Planning Inspectorate Reference: EN010012  
Our Identification Number: 20025459

**Planning Act 2008 – Application by NNB Generation Company (SZC) Limited for an Order Granting Development Consent for The Sizewell C Project**

**Deadline 8 Submission**

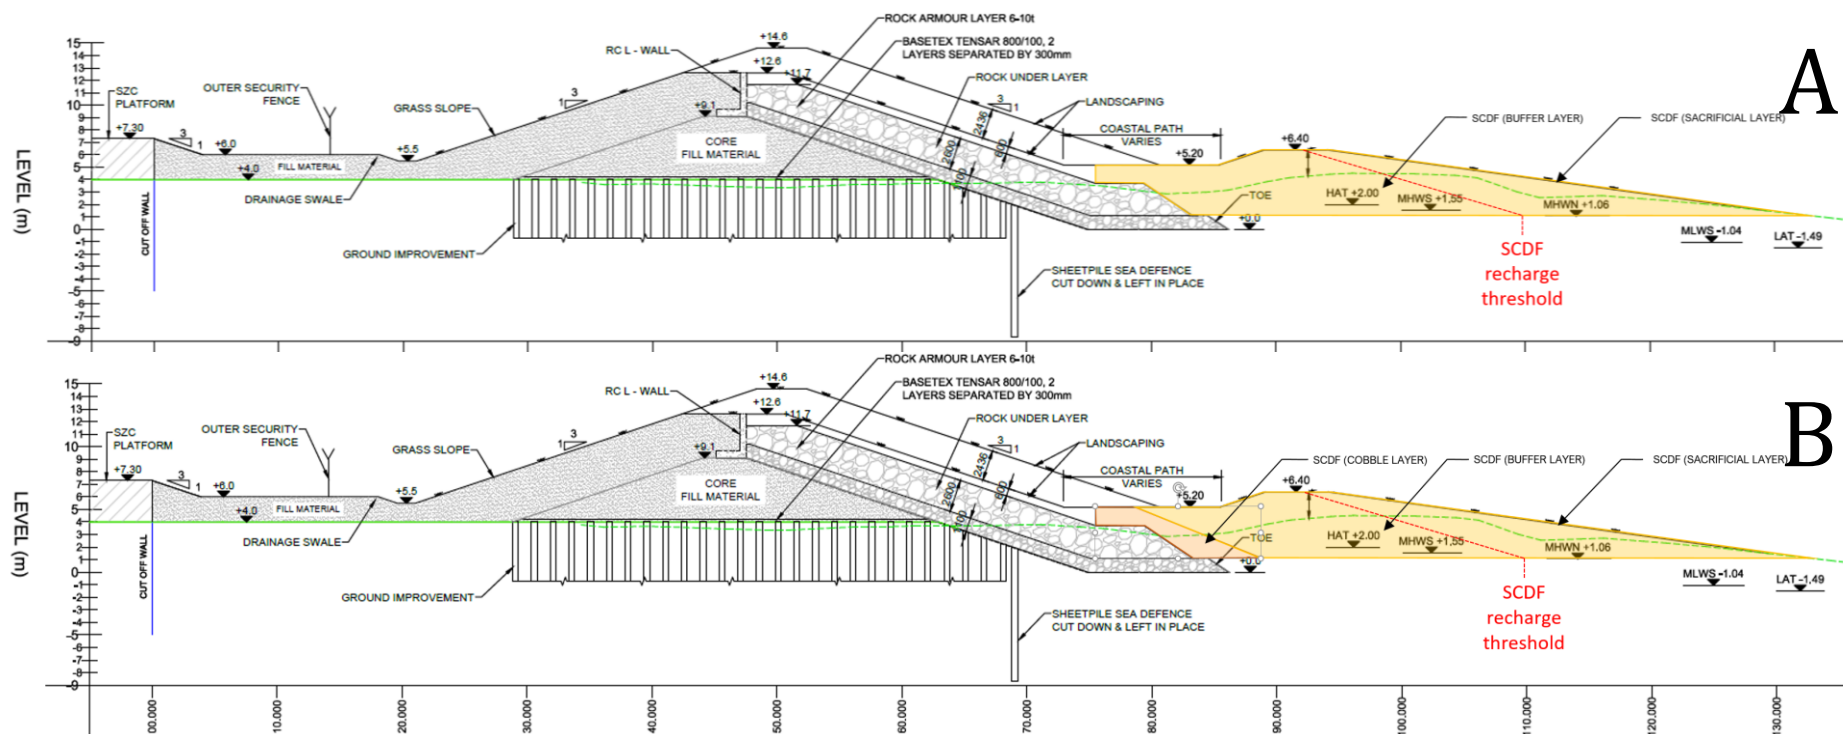
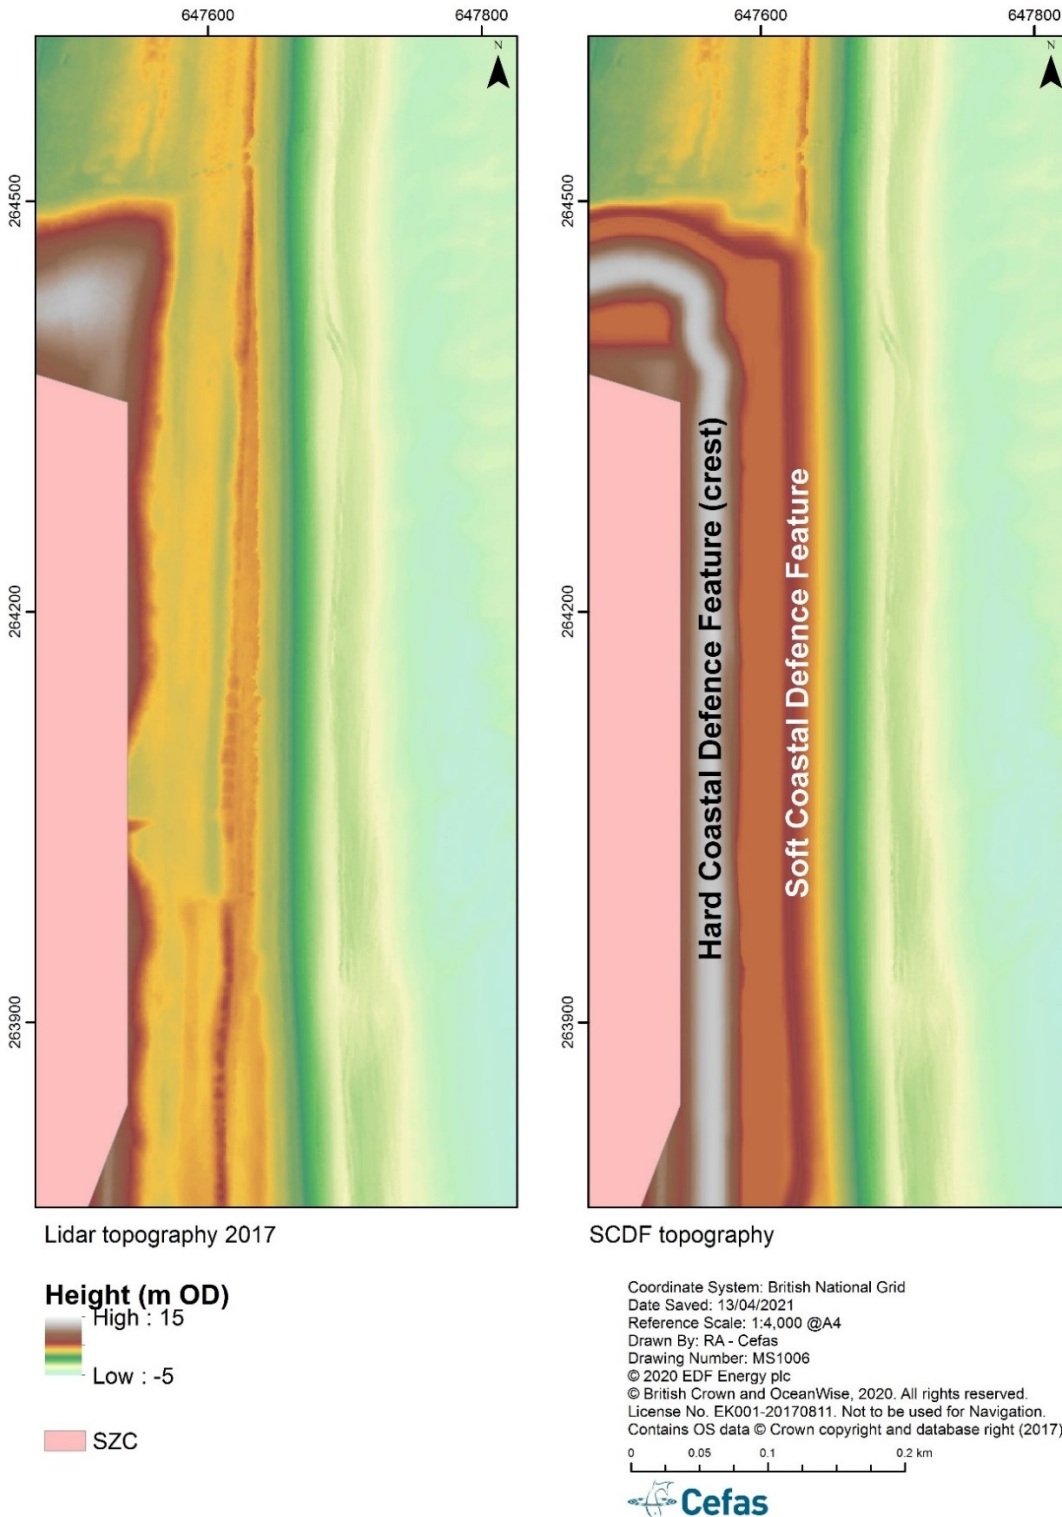
- 1.1.3.1 Based on the SCDF modelling provided by the Applicant, the MMO previously stated that we do not agree that using coarser material than the native grain for the sacrificial outer layer of the SCDF is the best option. See our detailed comments on this in section 5.1 of REP6-039, and section 3.1 of REP6-040.

- 1.1.3.2 During a meeting between the MMO and the Applicant on 16 September 2021 the Applicant updated the MMO that their default position has now changed, and they will commit to using material that is the same as the native grain size in the area for the SCDF, unless otherwise agreed in the future.

- 1.1.3.3 To ensure that the appropriate grain size is used the MMO advise that DML condition 41 (1) is updated to add “source, type and grain size of the material to be deposited;” to the list of information that must be provided to the MMO prior to construction of the SCDF.

- 1.1.3.4 The MMO would also advise that the commitment to using material that is the same as the native grain size as a default position should be stated
